Support Letter from agent – M/59/20/HH

From: Andy Young [REDACTED]
Sent: 25 September 2020 10:15
To: Zac Denton <Zac.Denton@arun.gov.uk>
[REDACTED]
Subject: RE: Consultation Responses

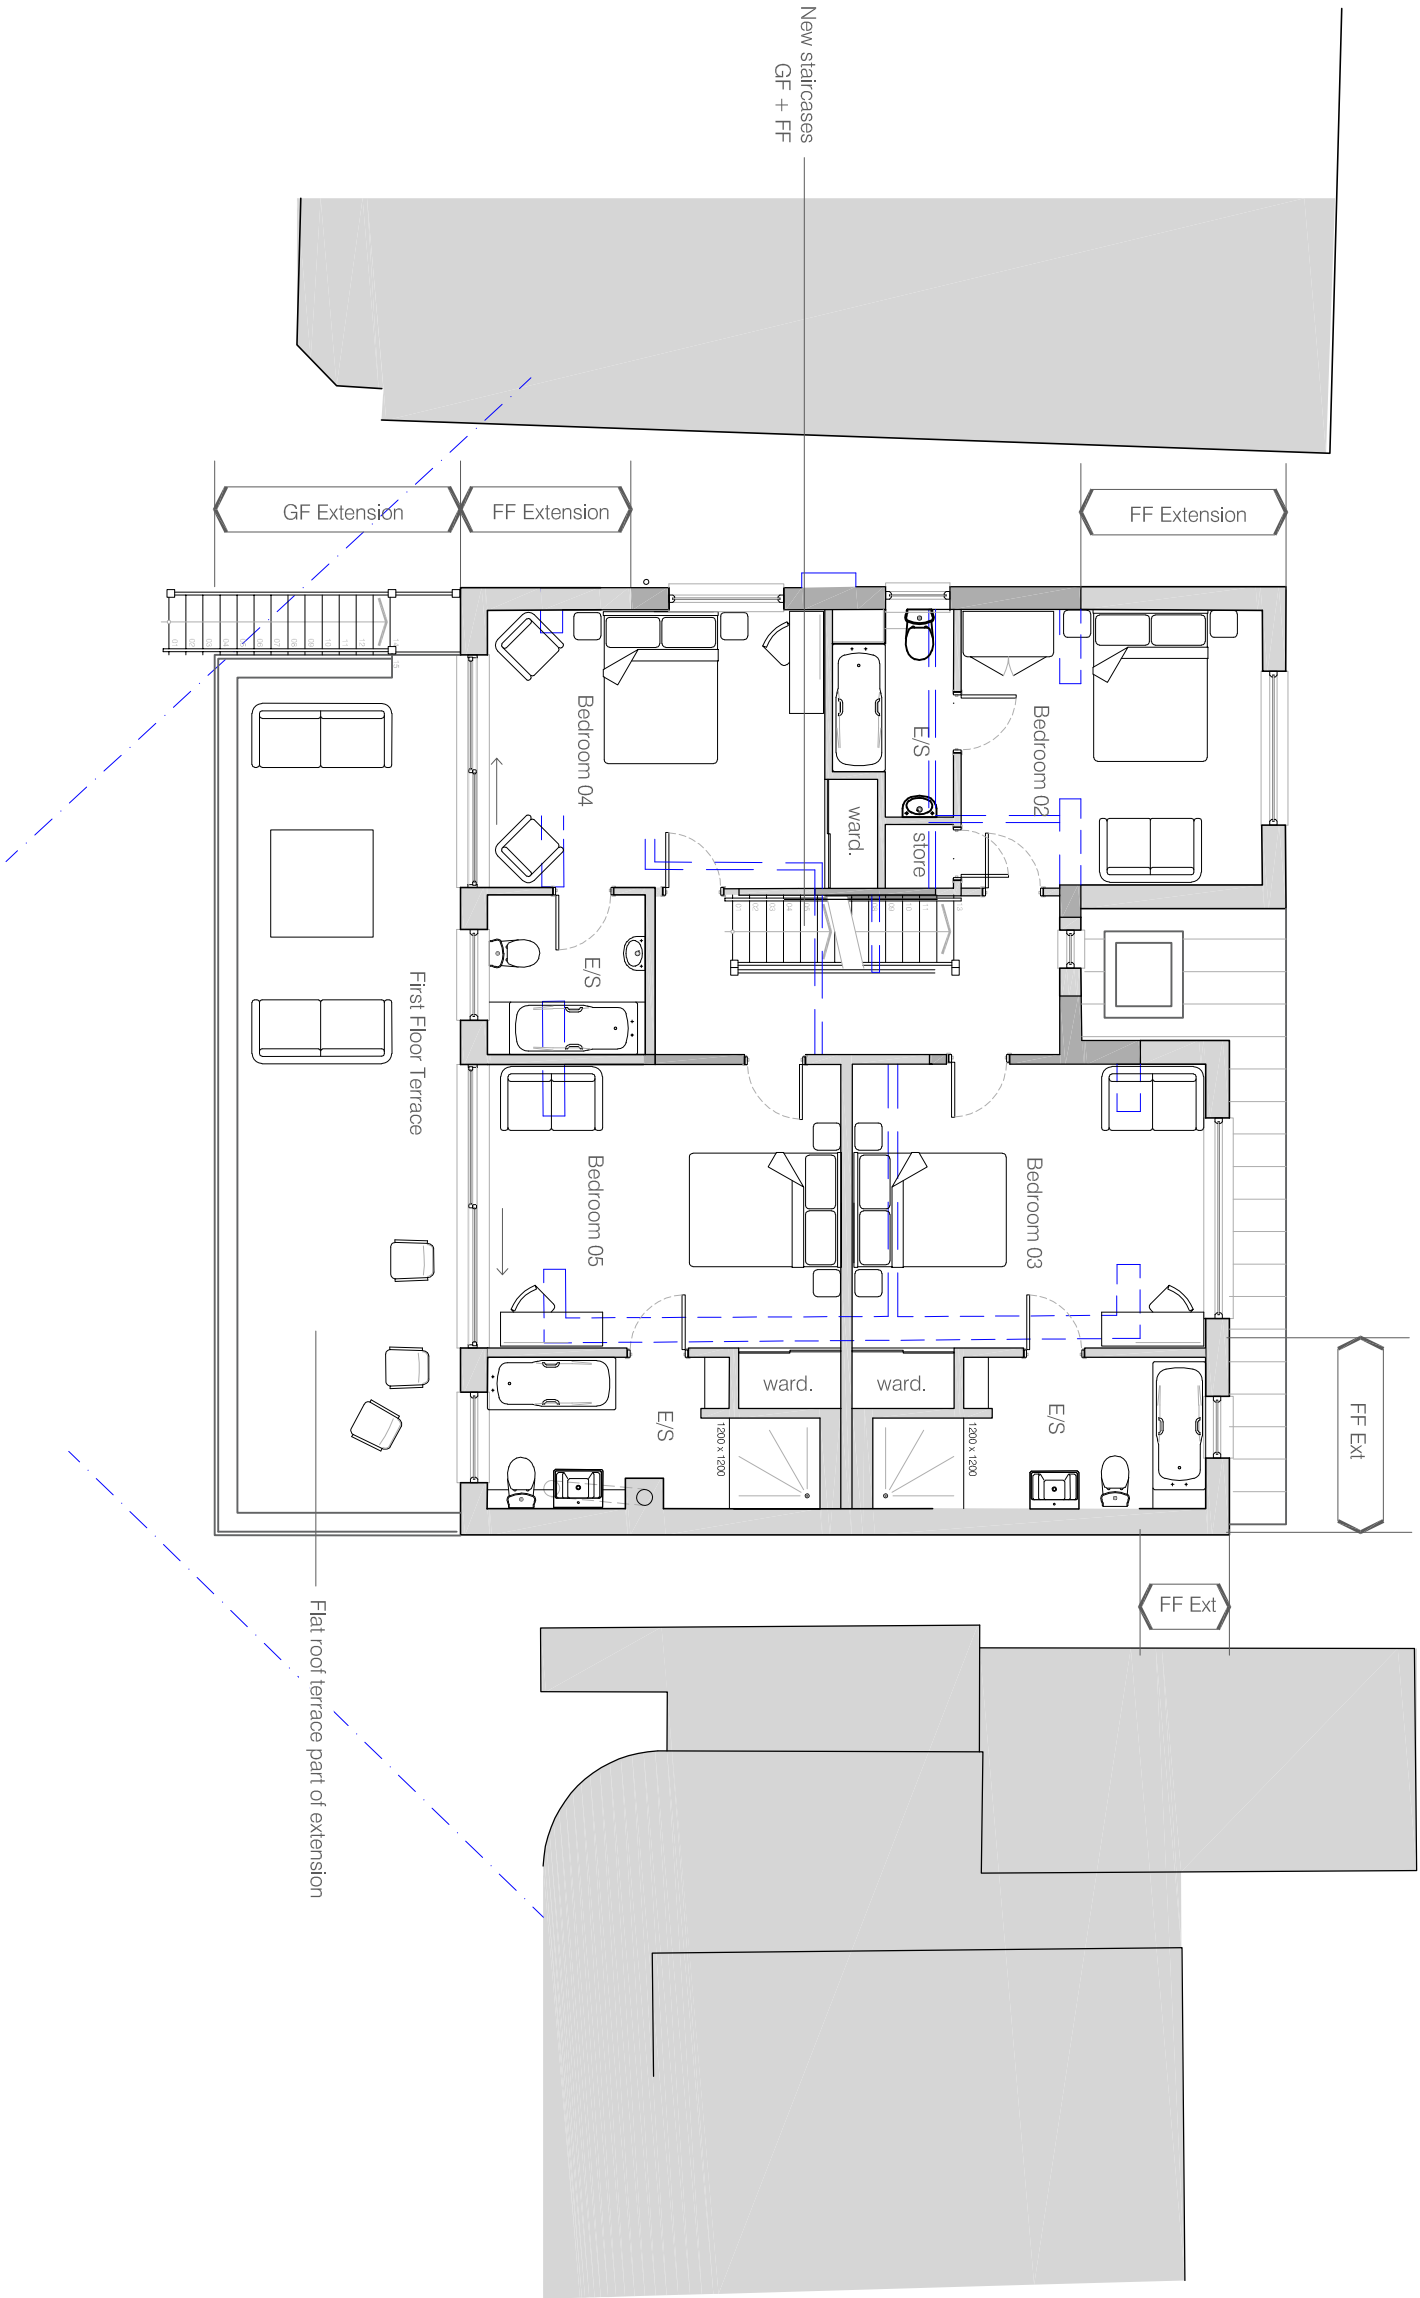
2. The concerns regarding privacy from the balcony the staircase is one we have encountered on previous schemes. The common design solution is to erect a 1.8m side screen on the balconies to limit the 45° view across a neighbours garden, which we have included in this scheme. This serves as a two-fold measure to protect the applicants privacy from the windows which already face across their site and vice versa.

The extensions have been limited in length to the south so that the end of the building and the screens meets a 45° line cast from the centre of the black framed window on the first floor of

We are proposing that the staircase is to be constructed with Millboard (composite resin) treads over a steel structure with a glass balustrade. The Millboard treads would provide sound absorption under foot compared to a bare steel staircase. If the authority has further concerns, alternatives such pre-cast concrete flight of stairs and / or a timber hit + miss screens to the side would offer better acoustic performance.

CLIENT **Mark & Melissa Muscat**
PROJECT **56 Southdean Drive**
DRAWING TITLE **Section + Outbuilding Elevations**

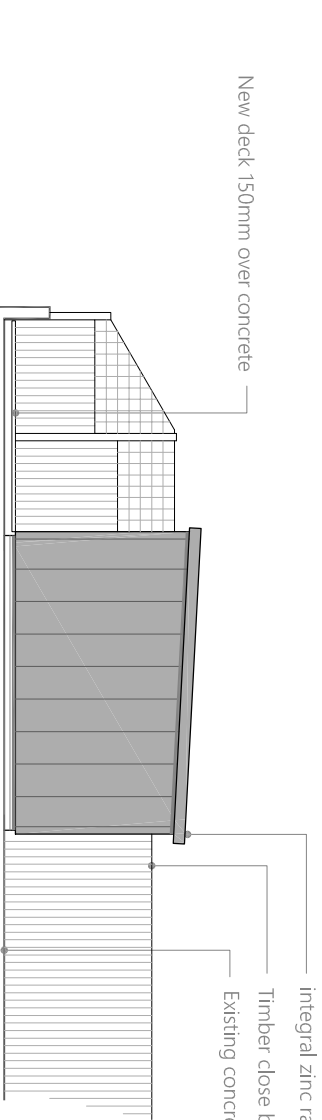
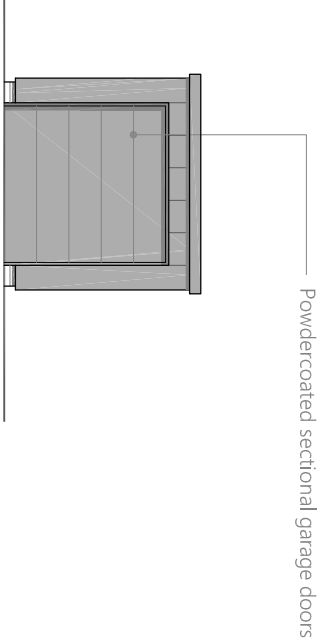
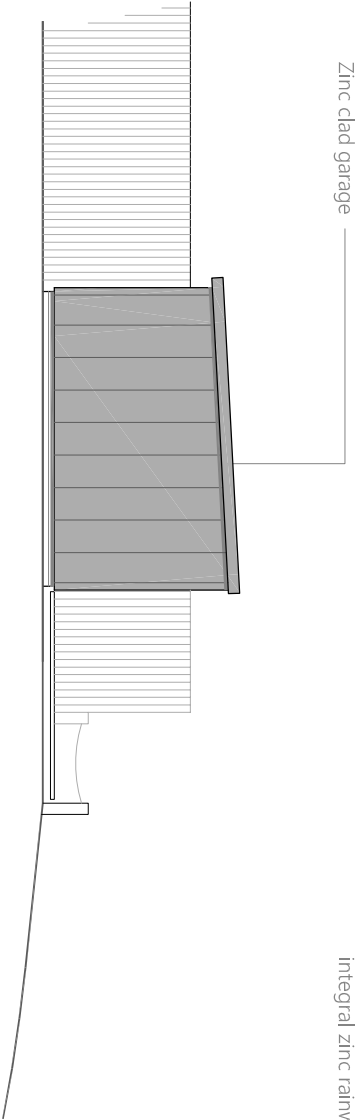
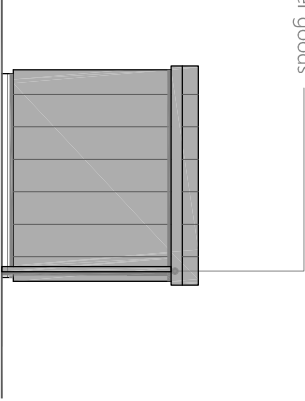
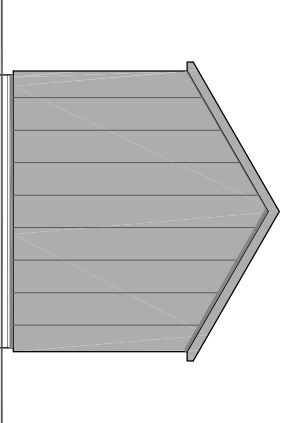
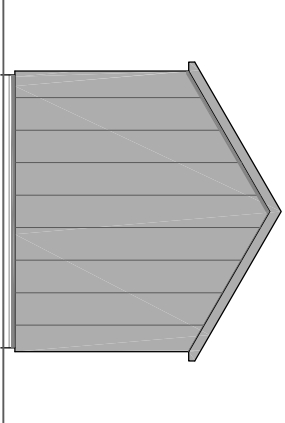
3. The store to the beach side is within the size parameters of permitted development rules and replaces a not dissimilar size shed that is in that location. The building is largely hidden by mature planting in both the gardens of no. 54 + 56. The materials chosen respond to the top storey of the proposed development rather than any others within the immediate vicinity. Should the choice of material be a concern from a planning policy perspective then we would welcome the opportunity to address this prior to the authority making its decision.

4. There are limited opportunities on any of the sea front plots to include external storage of garages and the space forwards of the building line is one of those limited opportunities. If the siting is of a concern to the authority then there are alternative locations within the front garden that could be considered prior to the authority making its decision.
